Proposal: Retention of horse-box hire business, mobile home, office/staffroom and an area of hardstanding.

Site: Longreach Eastergate Lane, Eastergate PO20 3SJ.
EG/35/12

Our Ref: PLAN-000744

PLS
file
Proposal: Retention of horse-box hire business, mobile home, office/staffroom, workshop storage building and area of hardstanding.
Site: Longreach, Eastergate Lane, Eastergate, PO203SJ.
EG/35/12

TITLE	SITE PLAN
ADDRESS	LONGREACH EASTENGATE LANE PO20 3SS
SCALE:	1:200

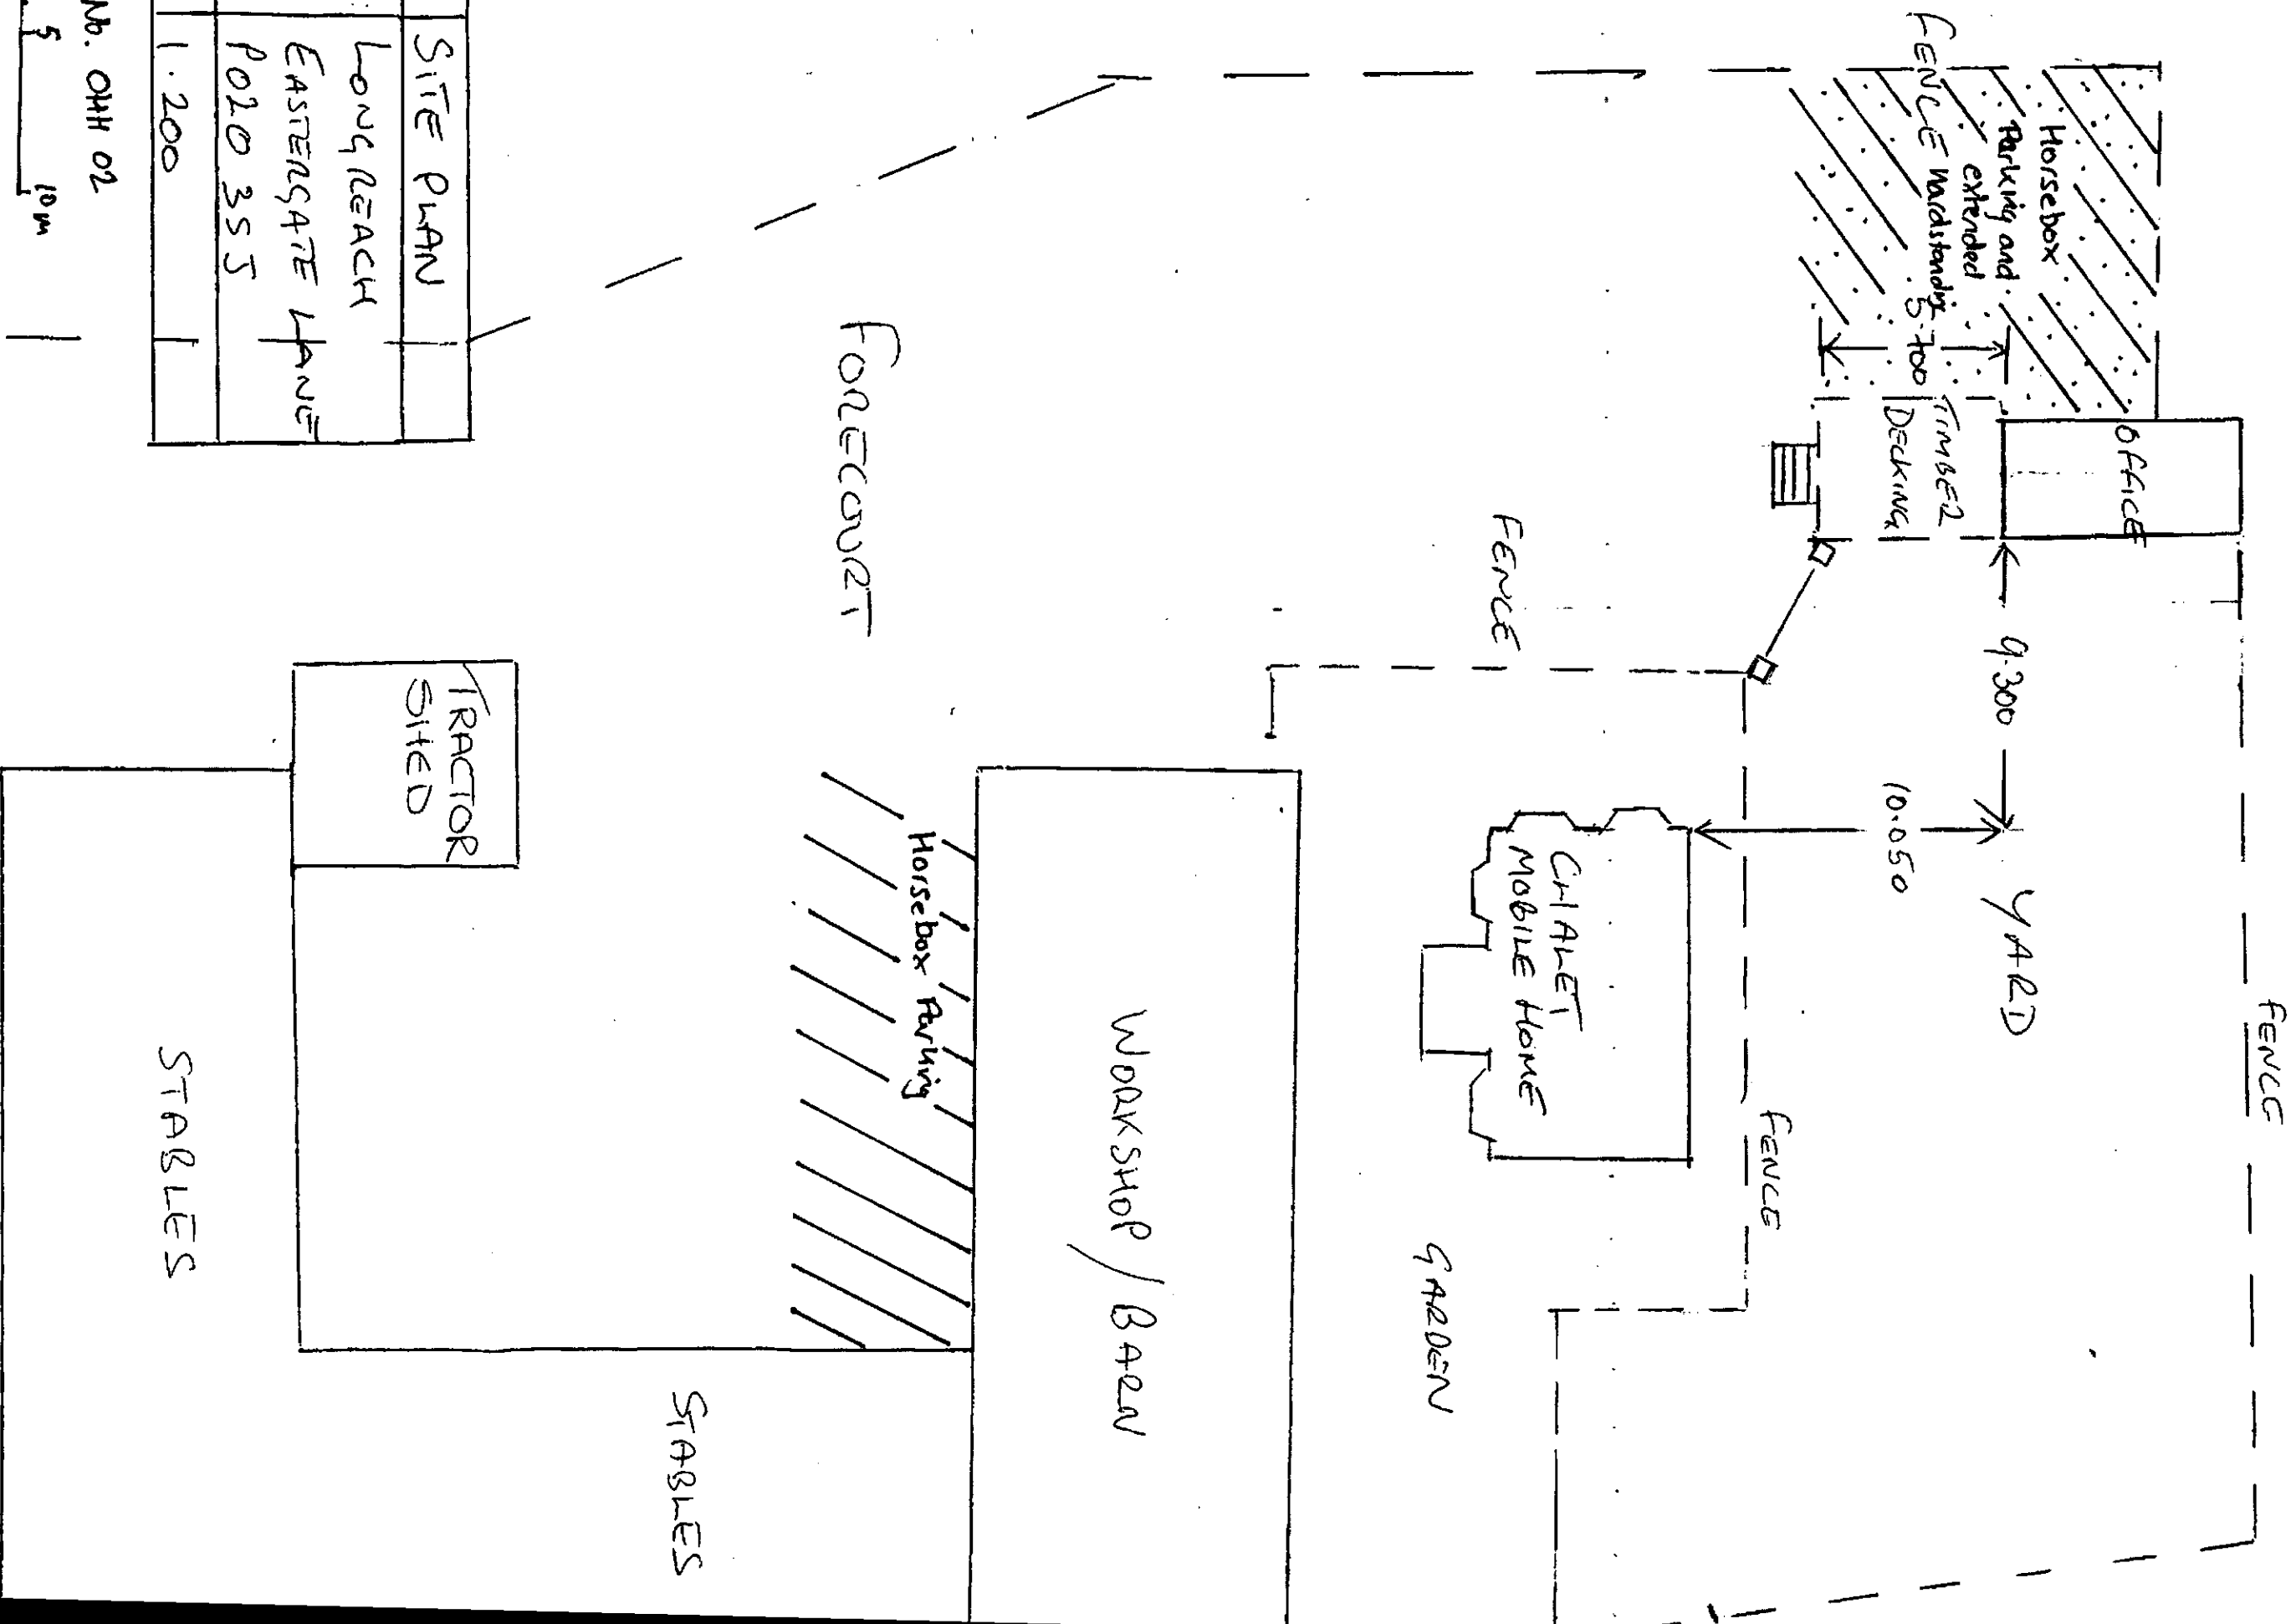
The applicant is advised to consult the Environment Agency directly regarding the use of a septic tank drainage which disposes of effluent to sub-soil irrigation. The owner of the premises will need to maintain the septic tank to ensure its long term effectiveness.

The Council's Building Control officers/technical staff or Environment Agency should be asked to comment on the adequacy of soakaways to dispose of surface water from the proposed development.
